Application Ref: 24/00140/DPP Pre-application Ref: \_\_\_\_\_ Online App

<p><b>UPRN:</b> 000120024987 (If <b>NO</b> UPRN – Admin to contact Technician)</p> <p><b>Site Address:</b> <i>(Leave blank if no UPRN)</i></p> <p>12 GORDON STREET EASTHOUSES DALKEITH EH22 4DS</p>	<p><b>Description of Proposal:</b></p> <p>Erect a single storey to rear of dwellinghouse and a single storey garage extension to side</p>
---	---

**Drawing number:**  
24/Miller/PP/002(-)

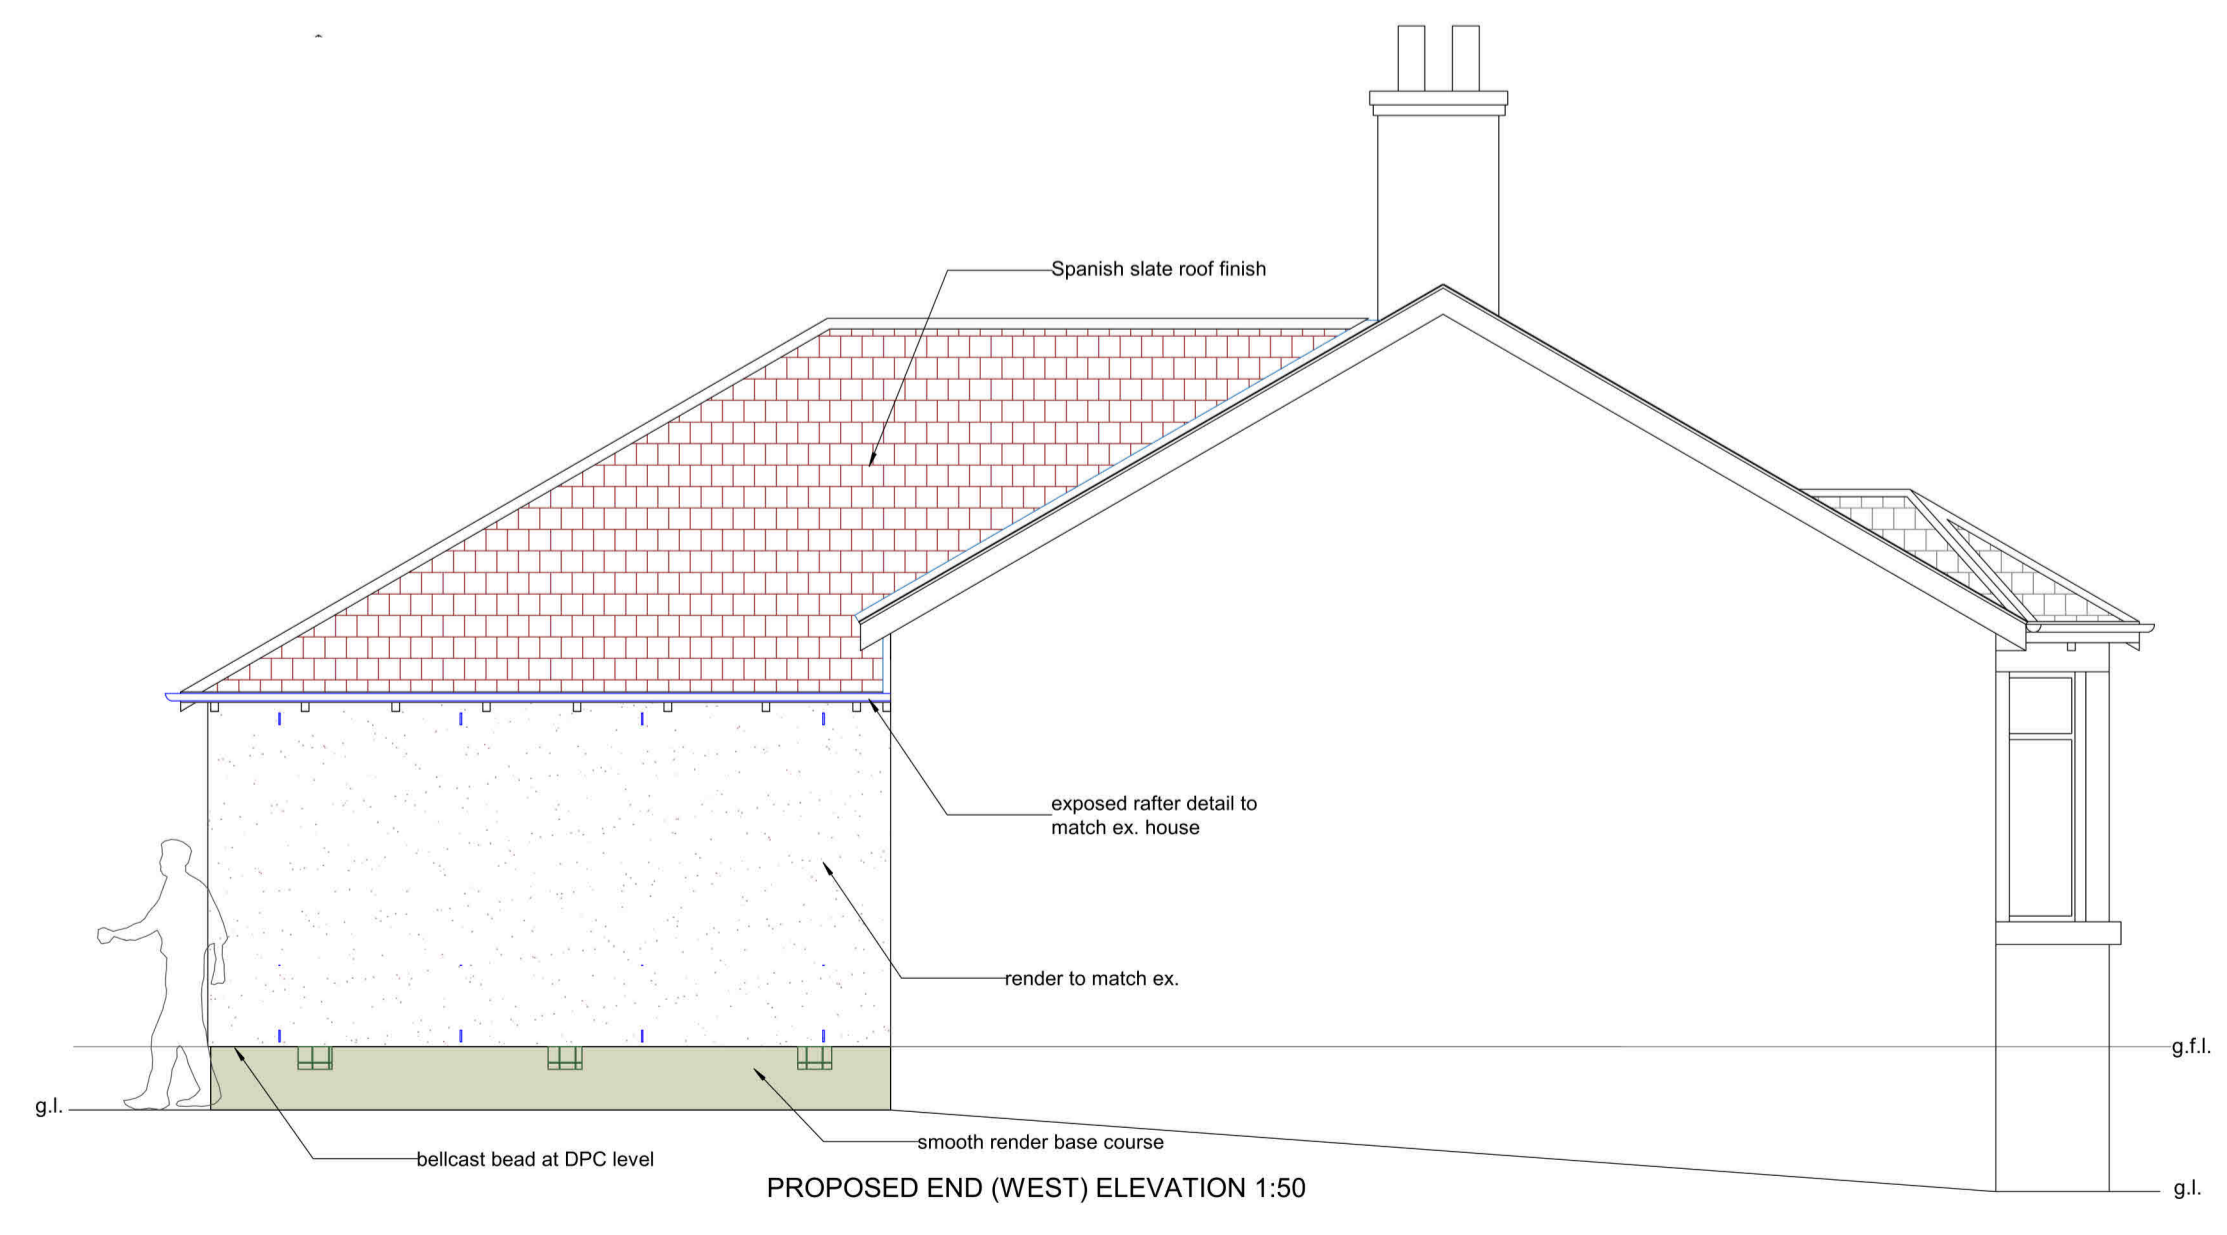
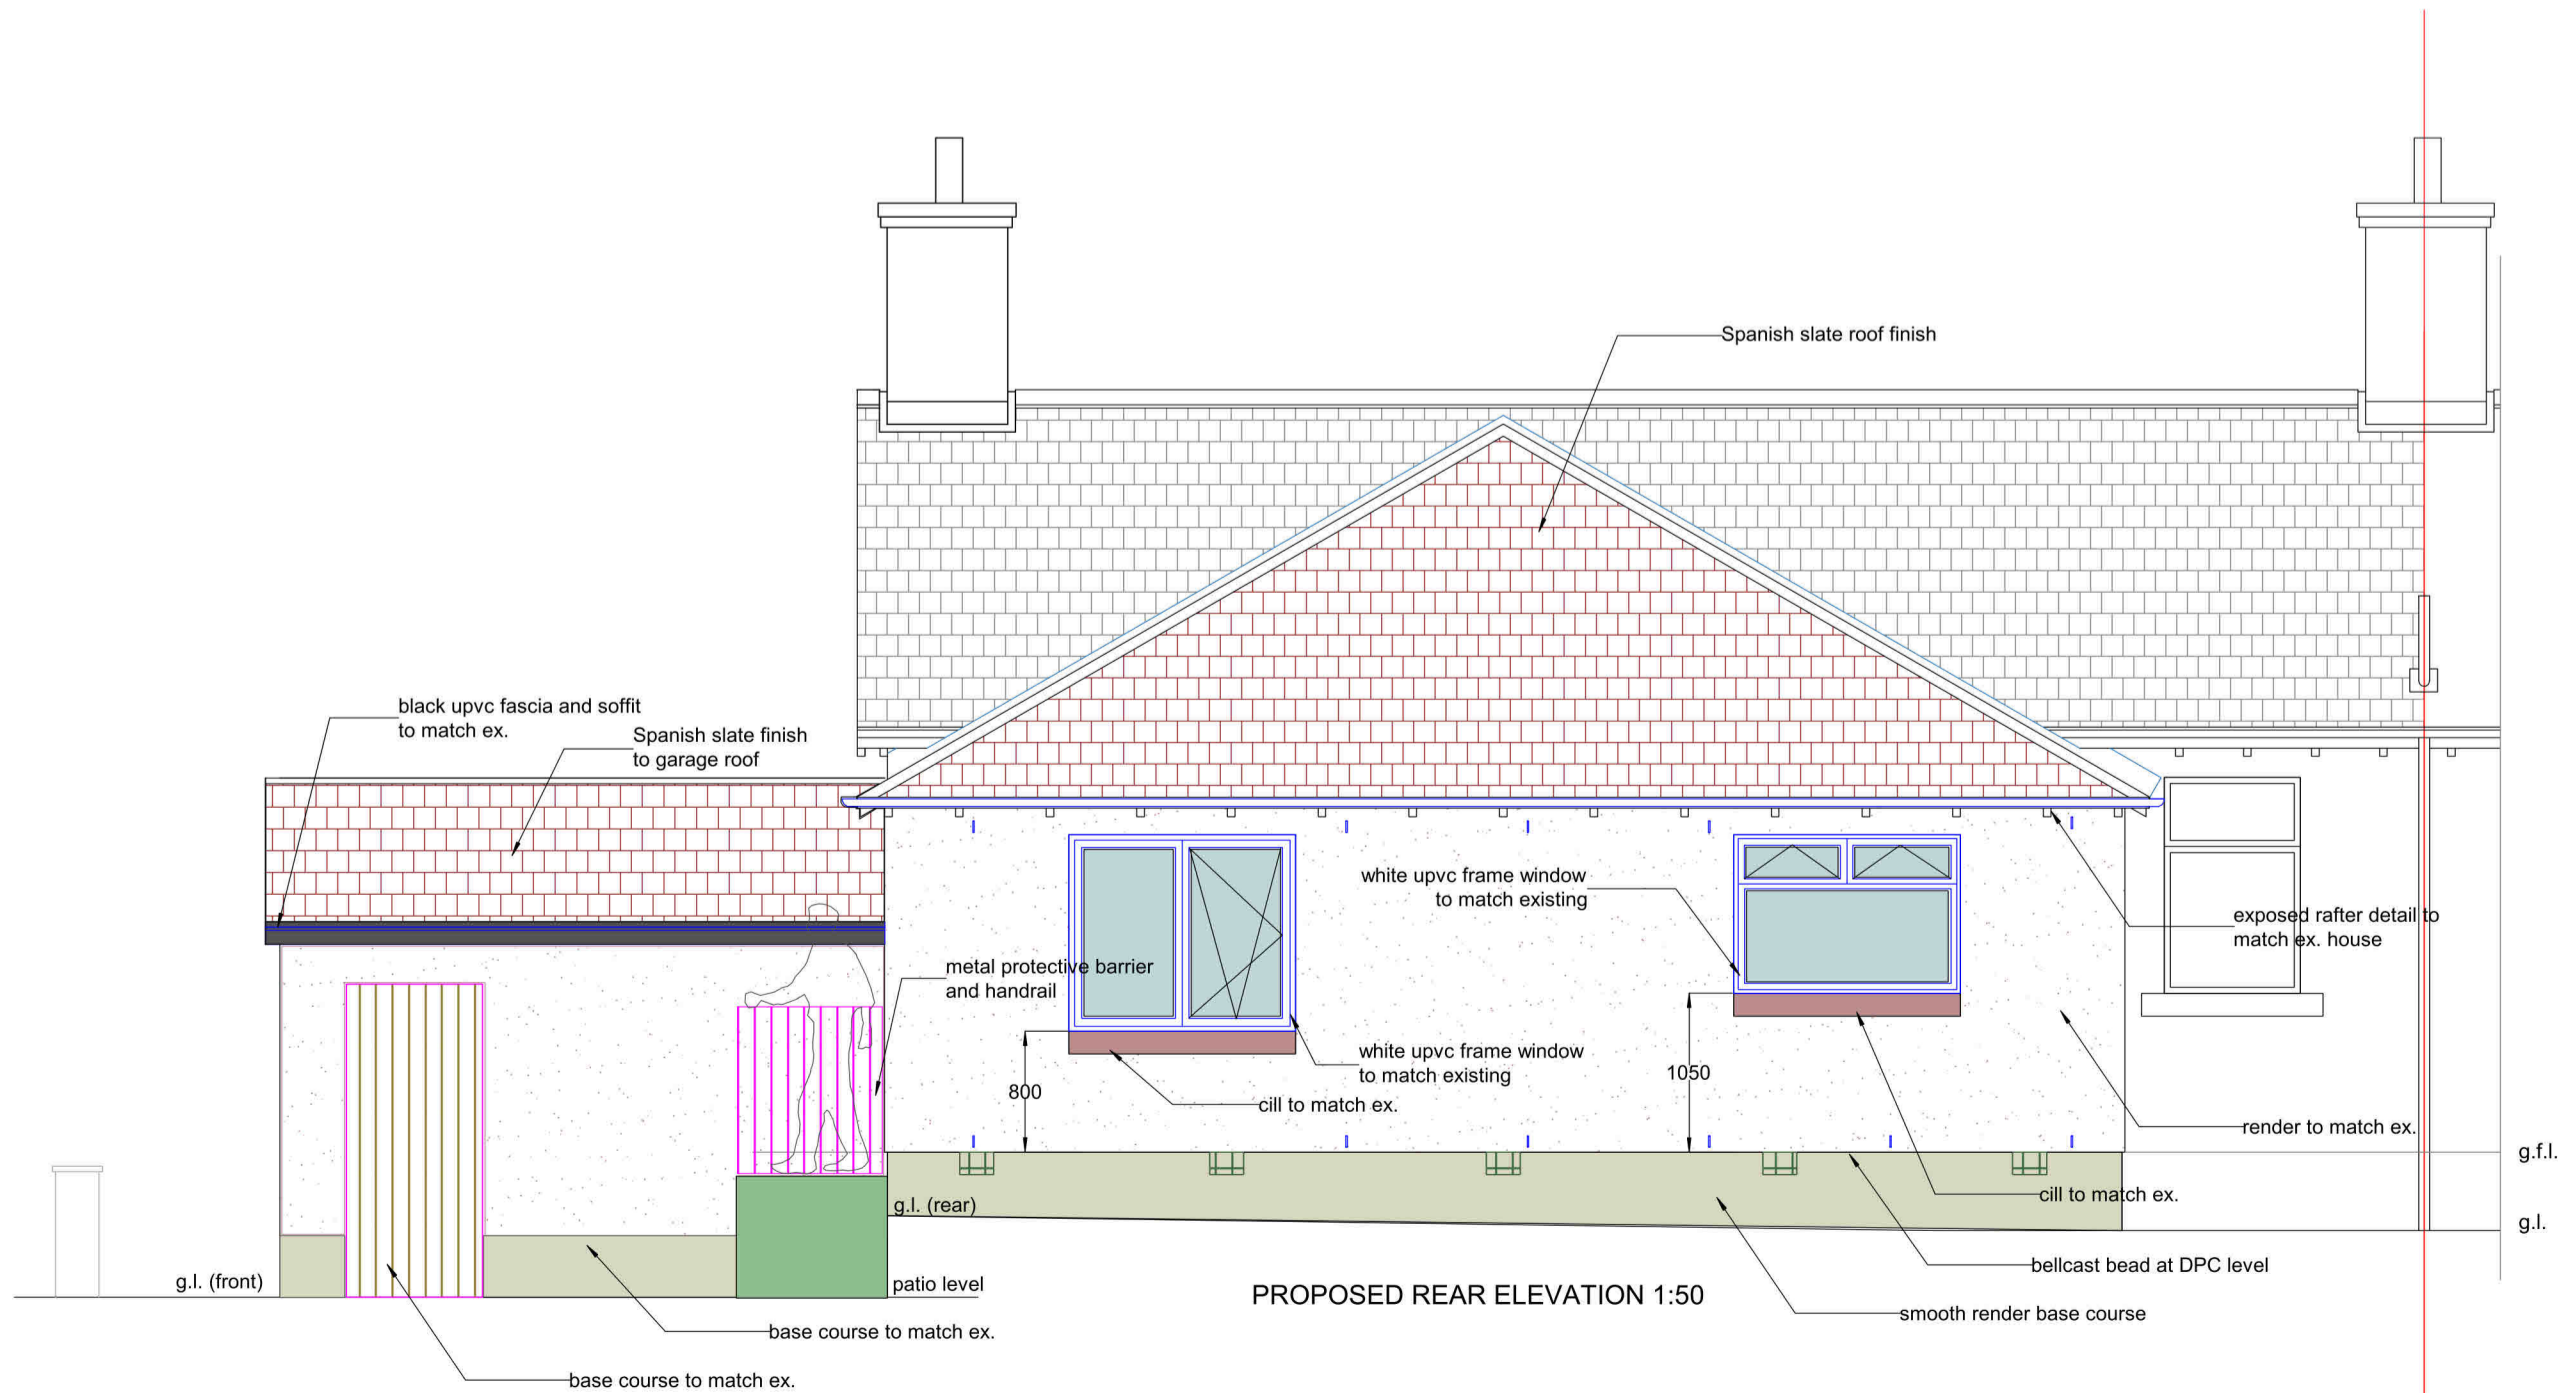
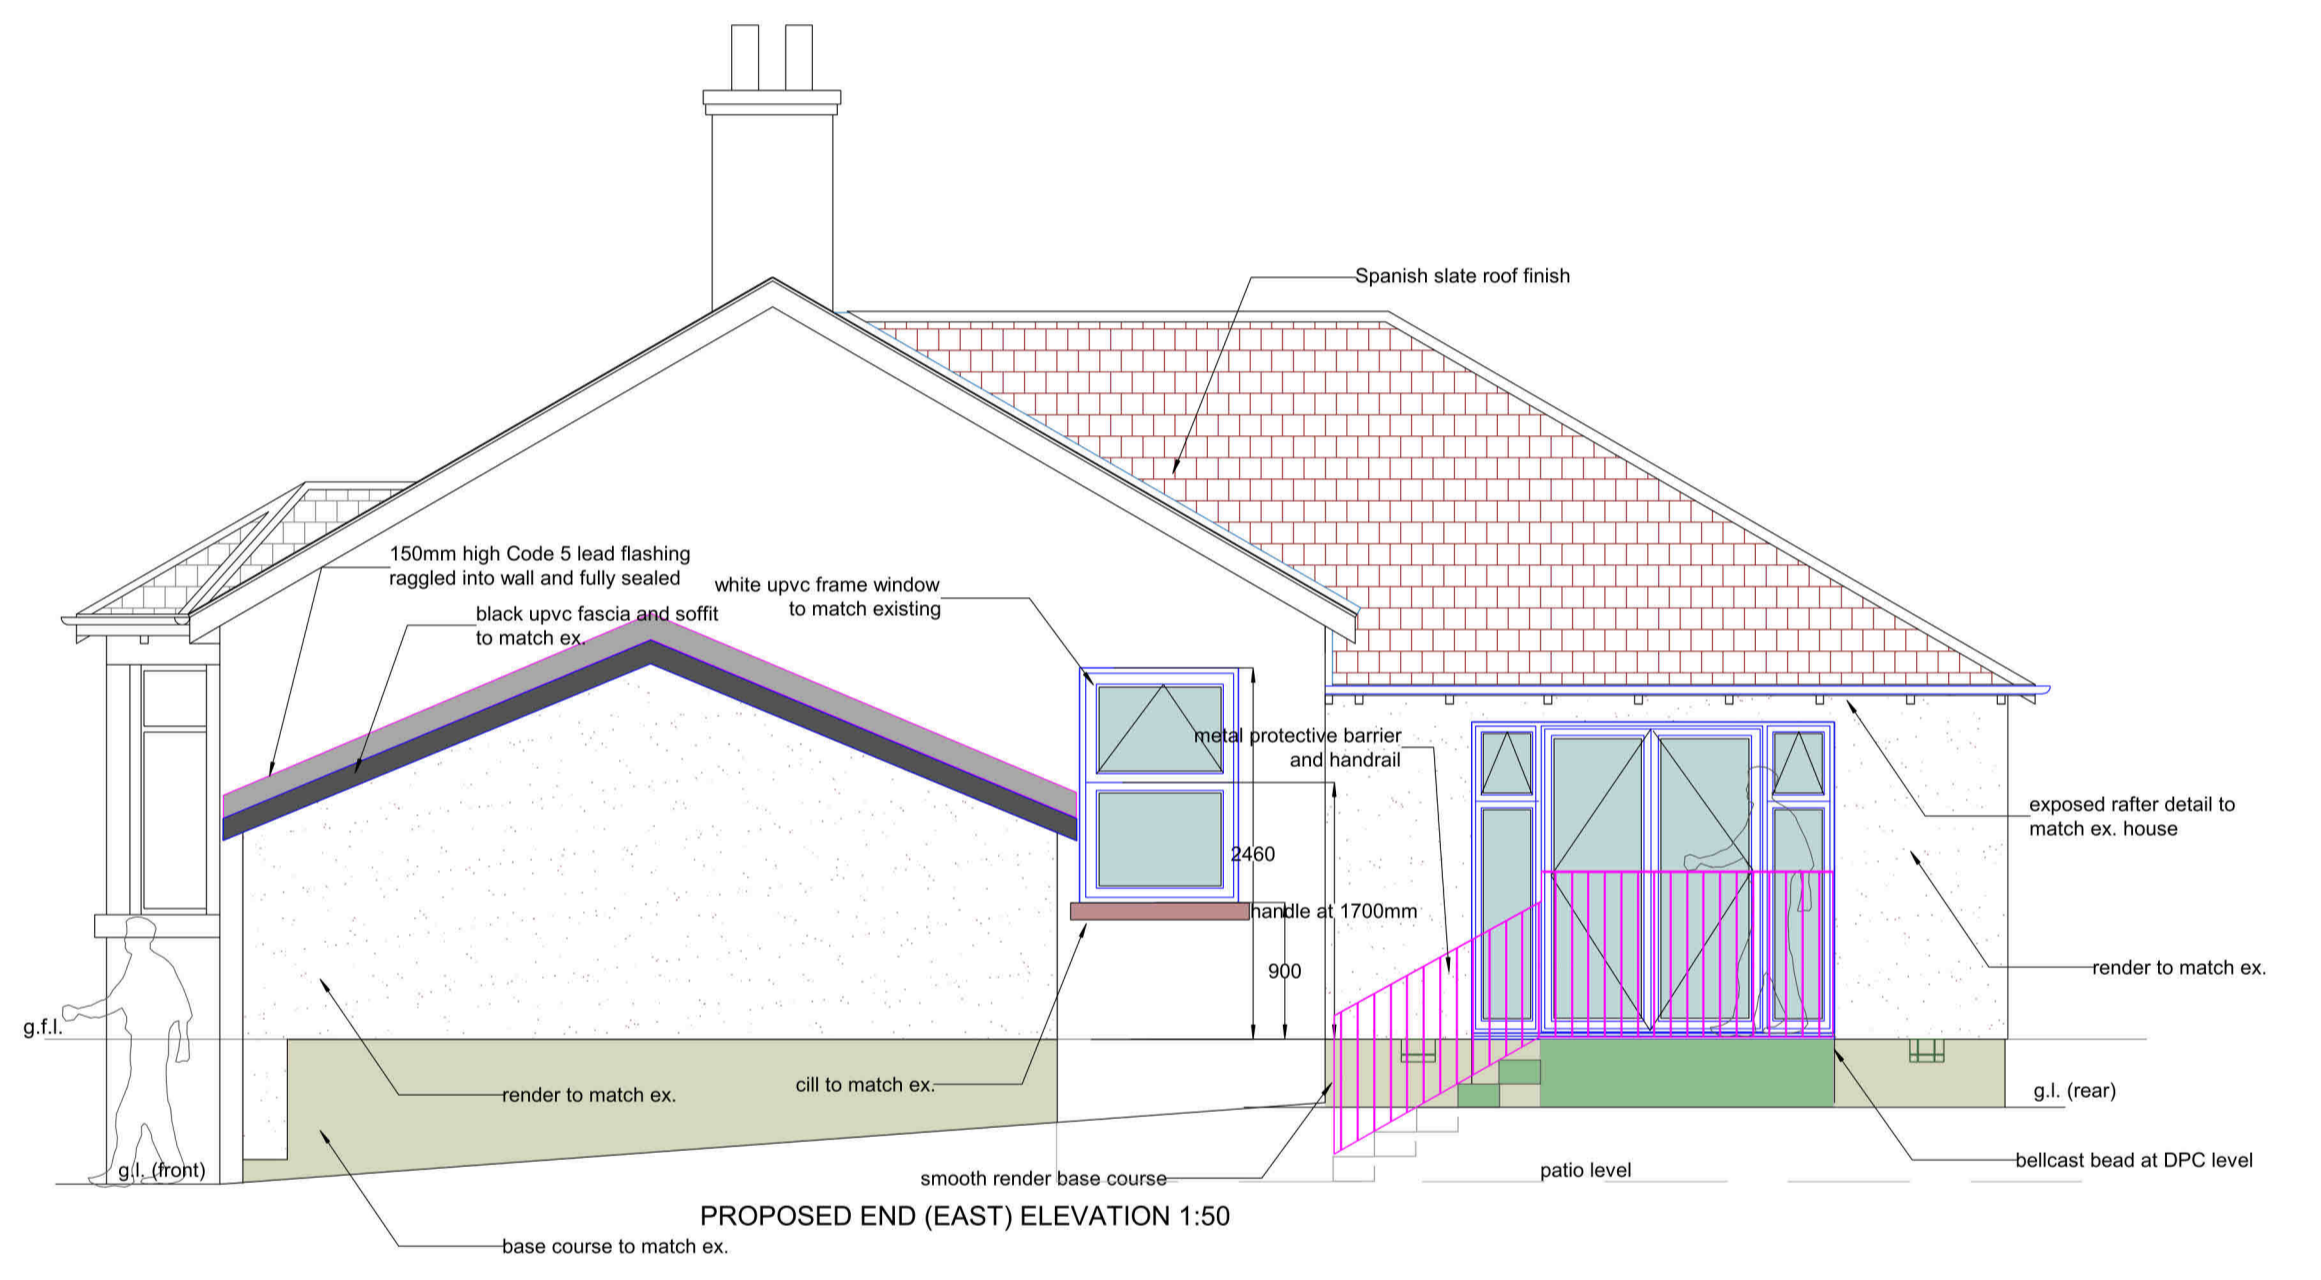
| <input checked="" type="checkbox"/> | <b>Inadequate Plans</b>       | The following additional plans are required: <ul style="list-style-type: none"><li>- Existing and proposed roof plan</li><li>- Existing end west elevation plan</li><li>- Existing chimney not shown on proposed west elevation plan however it appears that this is to be retained. Please could you check this and confirm if correct.</li></ul> |

- For ease it would be beneficial if all existing and proposed plans were shown on separate drawing sheets. Currently the proposed front elevation is contained on the drawing sheet with existing elevations.
